GATE BURTON ENERGY PARK

Representation to Planning Inspectorate from:

Paul & Wendy Carter

Drawing Number
GH-144625001-LP-8

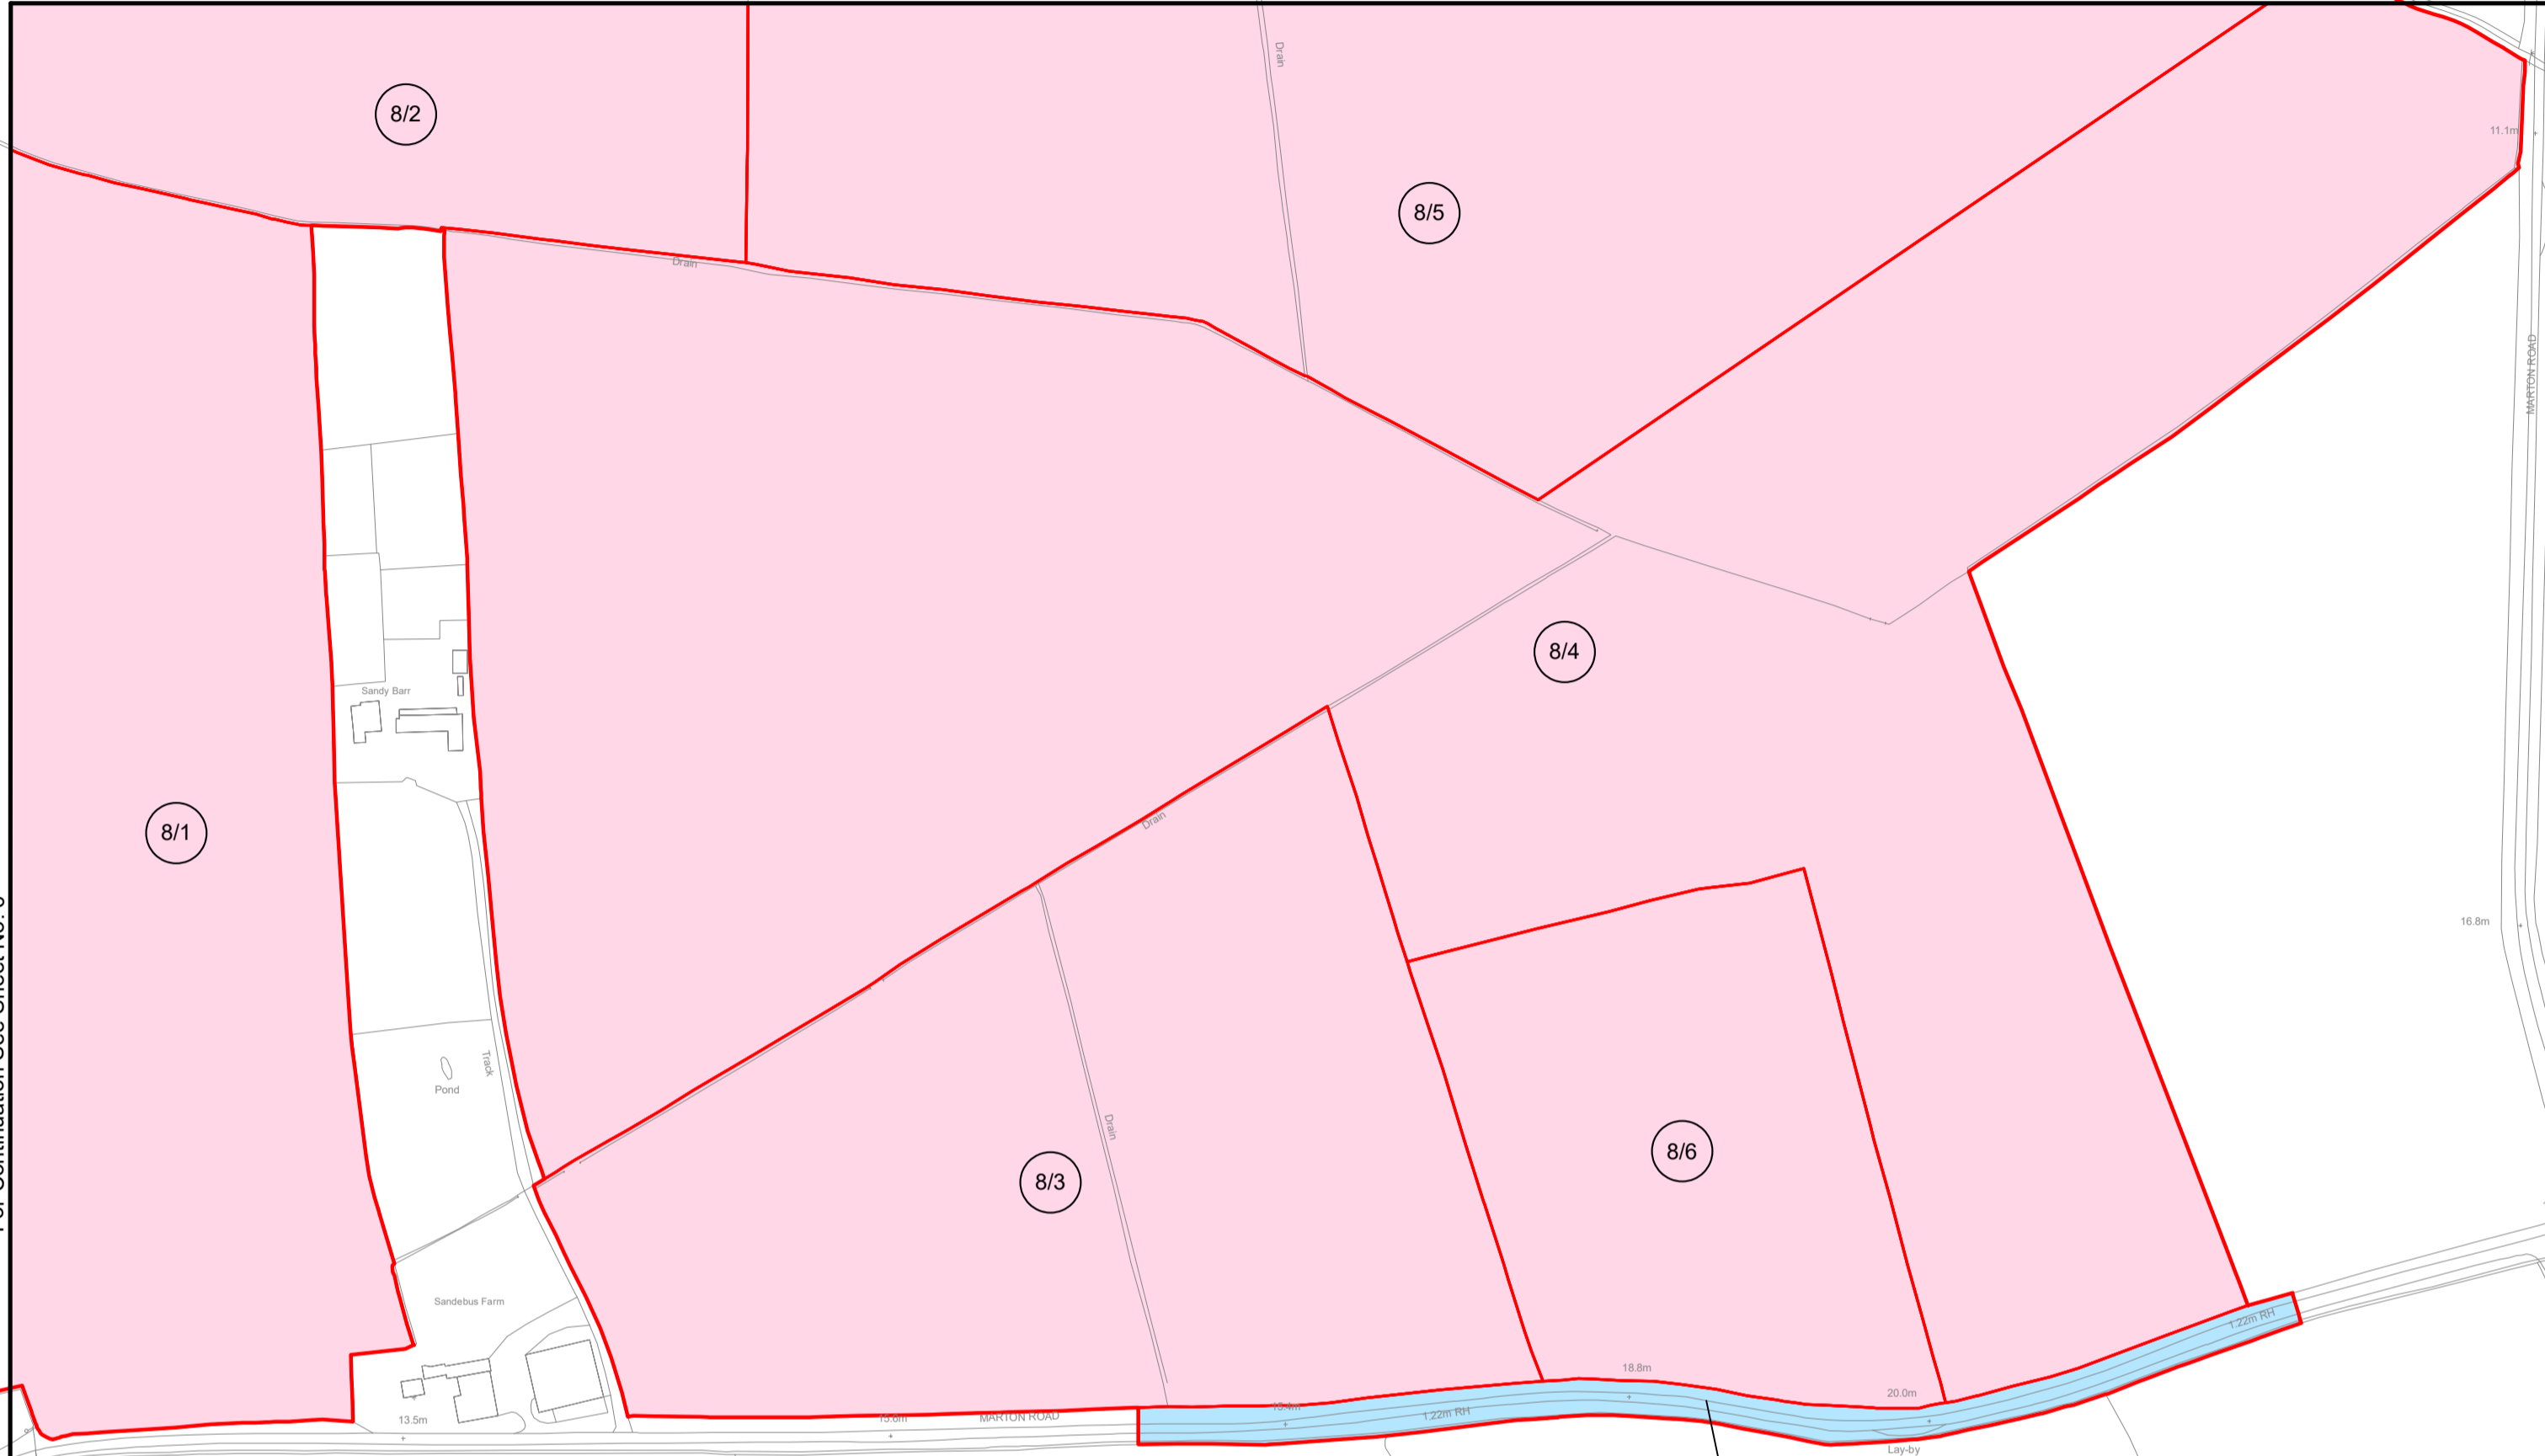
The developer has agreed to block accesses to field C7 with locked gates (designated 8/07 and 8/08 on sheet 8 of EN010131/APP/5.3). There is however still an issue with field C11 as its western edge is currently without any hedging or fencing and consequently open to ingress. This part of the site's perimeter, i.e. where the site abuts the shared accessway to our property, needs to be fenced to prevent unauthorised access to field C11 (which would allow unauthorised entry to other parts of the site, including field C10 which is adjacent to our property).
